# A47 Wansford to Sutton Dualling

**Scheme Number: TR010039**

## **9.24 Applicant's Response to the Examining Authority's Further Written Questions (ExQ2)**

April 2022

Drawing Title:  
**CROWN LAND PLANS  
REGULATION 5(2)(n)  
SHEET 6 OF 7**

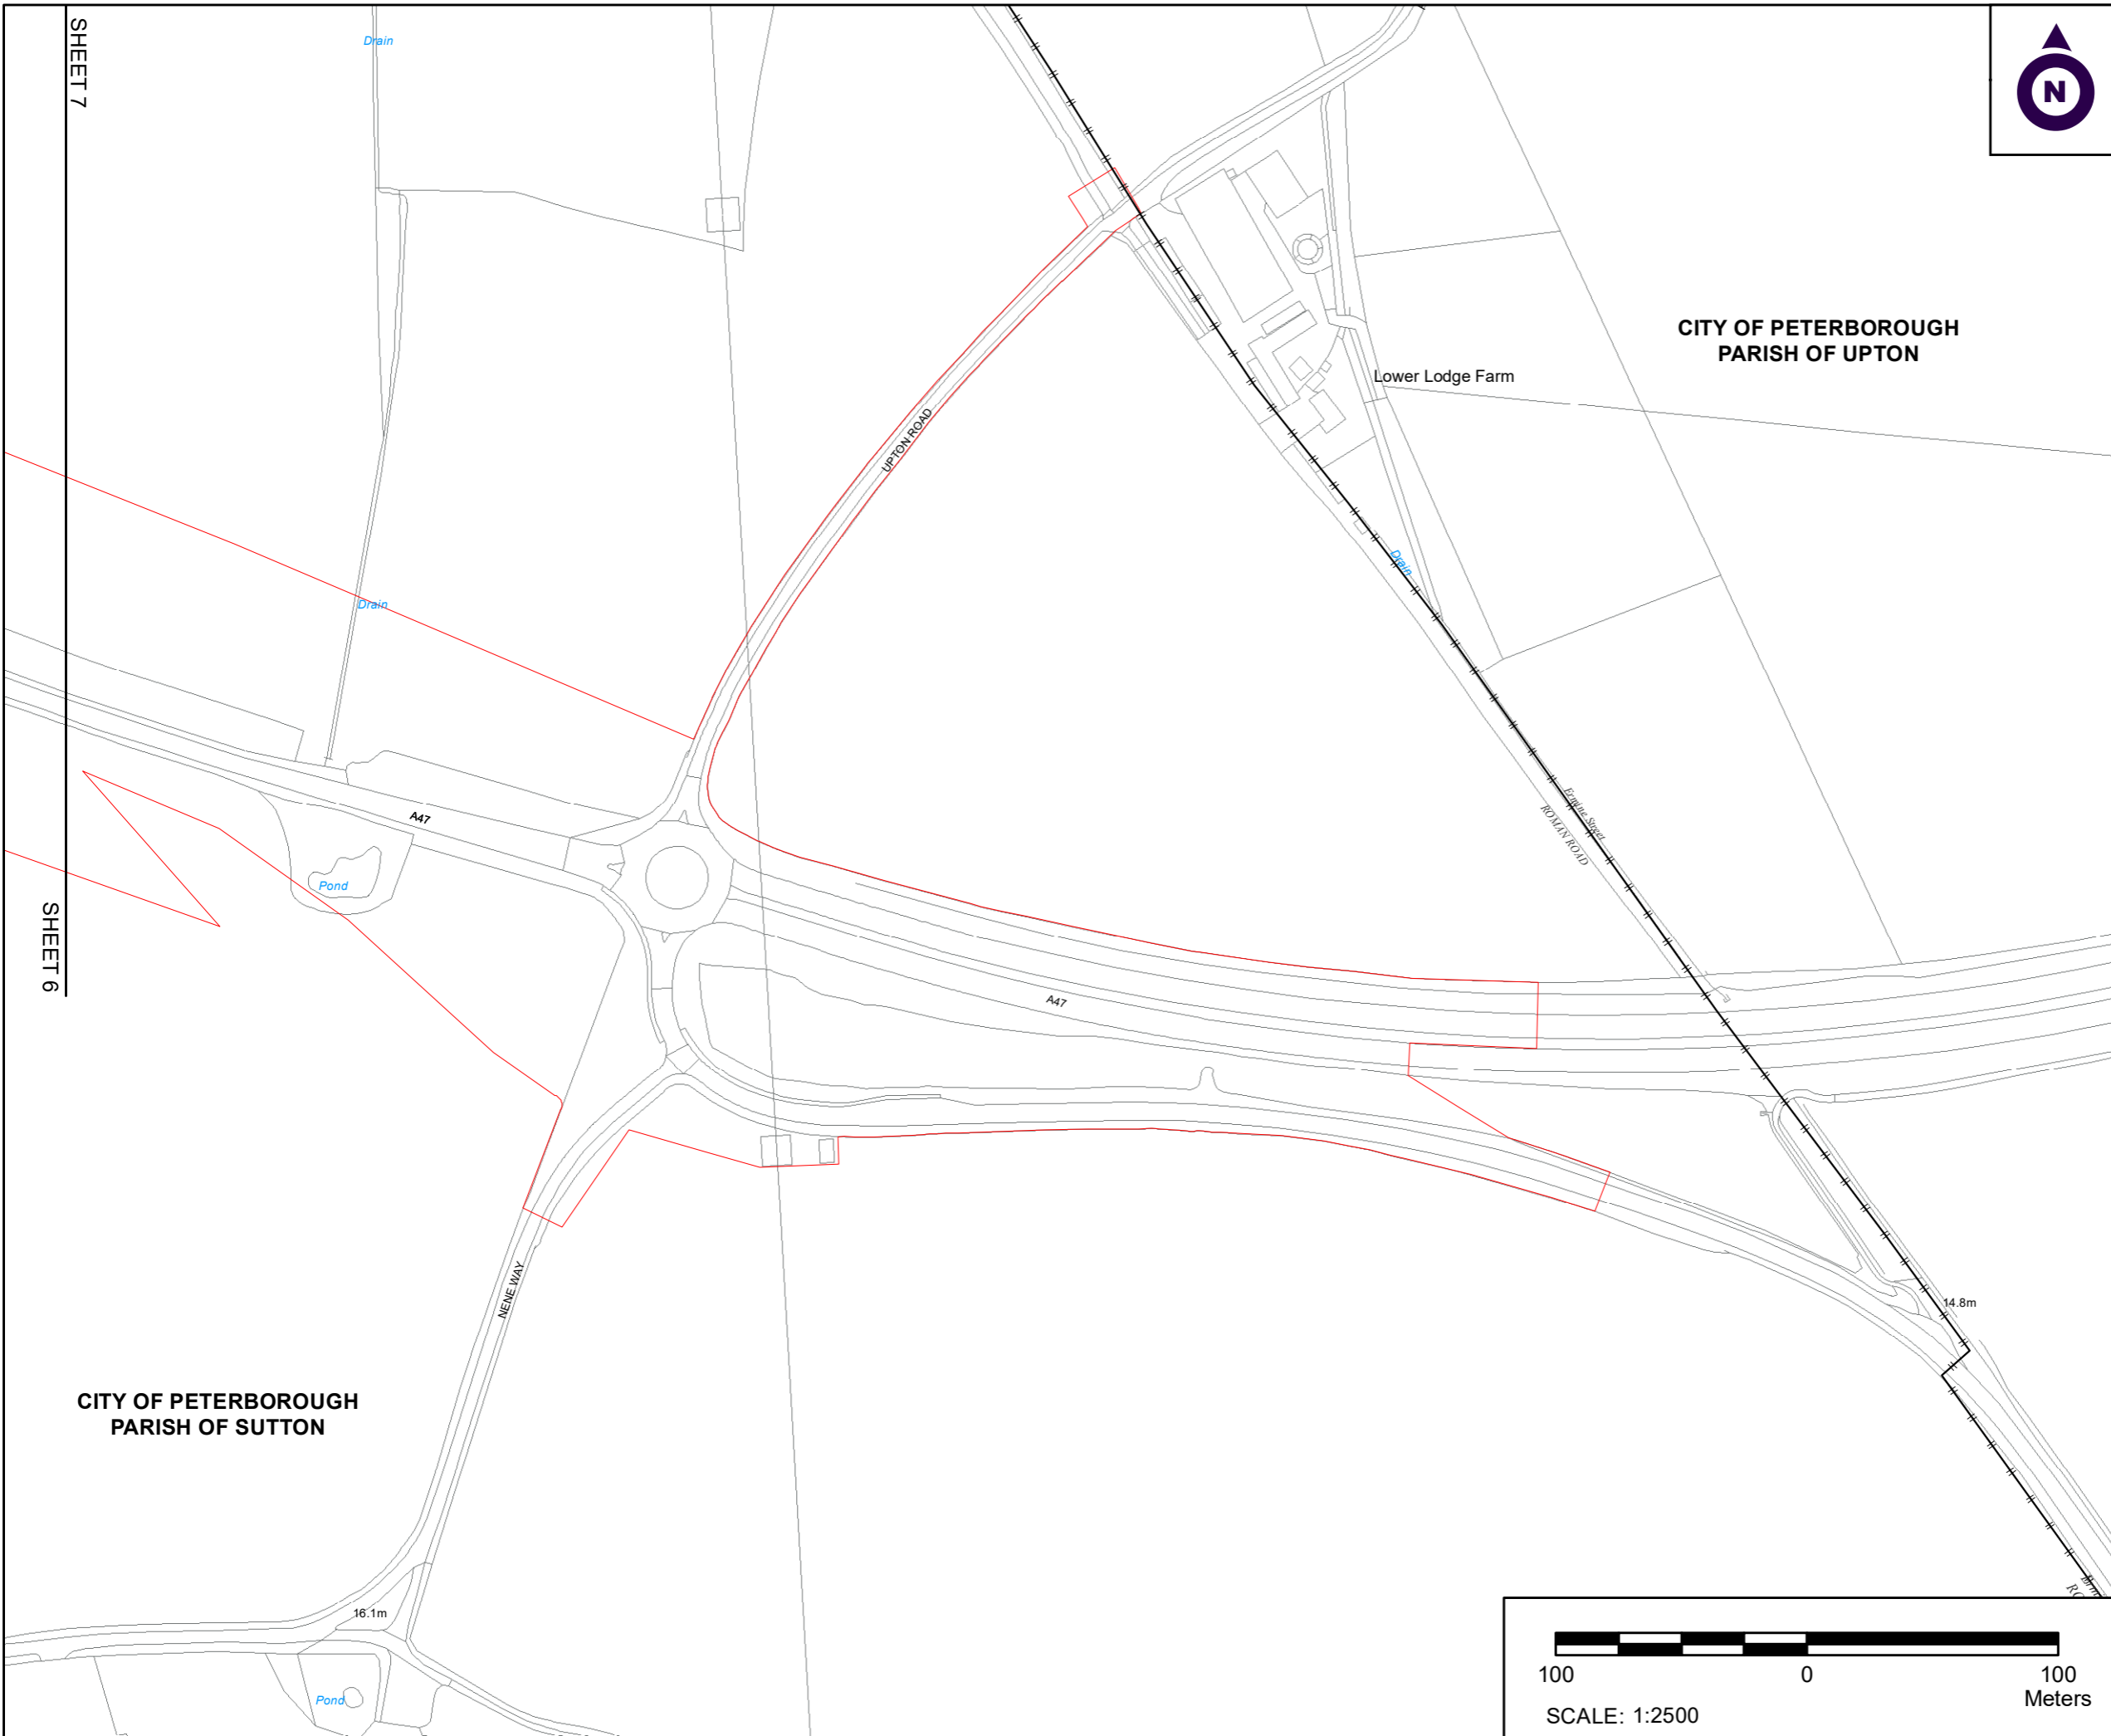
2.3.5.	The Applicant	<p><b>Land Plans</b> [REP2-003] and <b>Crown Land Plans</b> [REP2-007]</p> <p>a) The shape of Inset F showing the area around 6 – 12 (evens) Great North Road is not the same as that on the plans and includes additional land. Can these please be aligned?</p> <p>b) The same applies to Inset A on Sheet 5.</p> <p>c) Could Sheet 3 Inset B on Sheet 2 please be made larger and also the “cut-line” shown on Sheet 3 included.</p> <p>d) Neither Inset A nor Inset C on Sheet 6 appear to have been identified on the main plan. Could this please be included.</p>	<p>The Land Plans (<b>TR010039/APP/2.2 Rev 3</b>) and the Crown Land Plans (<b>TR010039/APP/2.8 Rev 2</b>) have been updated and submitted at Deadline 5 to address these points.</p>
